KITTITAS COUNTY DEPARTMENT OF PUBLIC WORKS

MEMORANDUM

TO: All Staff
FROM: Public Works Plan Review Team
DATE: May 30, 2024
SUBJECT: SP-24-00008 Frosty Pines II

DETAIL  
INGRESS, EGRESS, AND UTILITY EASEMENT  
PER APN: XXXXXXXXXXXXX

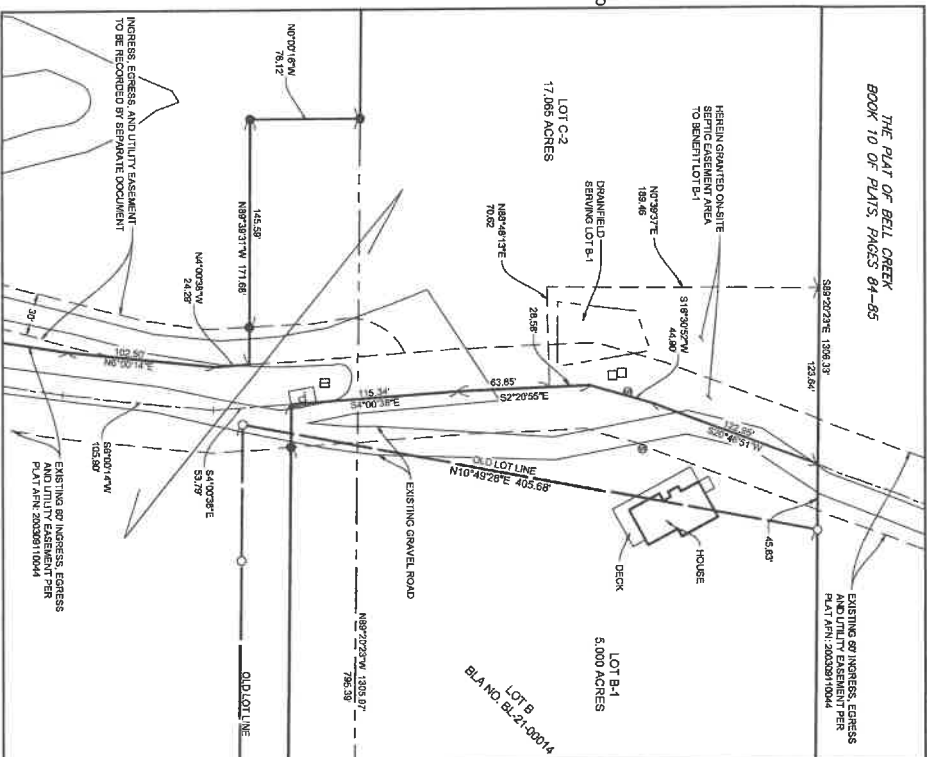
SURVEY	<p>The application meets the requirements of the Prelim Short Plat.</p> <p>The following will need to be addressed prior to final:</p> <ol style="list-style-type: none"> 1. The Easement shown to be recorded via separate document is not mathematically retraceable from the Short Plat. Please ensure that the easement document includes a retraceable description and does not simply refer to the Short Plat. 2. At minimum, the new division lines shall show corners, and have them set in the field. This includes the NW corner of Lot C-1 and the SE corner of Lot B-1. 3. The existing parcel (Lot B and C) are referenced to the record documents as BLA No. BL-21-00014. As this number is an internal application number to the county, these references should include Book and Page (B:44 Surveys, P:11) or the Assessor's File No. (AFN:20217230120). This occurs on the face of the map as well as the basis of bearings statement. <p>OF NOTE</p> <p>While vicinity maps are specifically excluded from text height legibility requirements, it would certainly clarify things to increase the text height to a more legible size.</p>
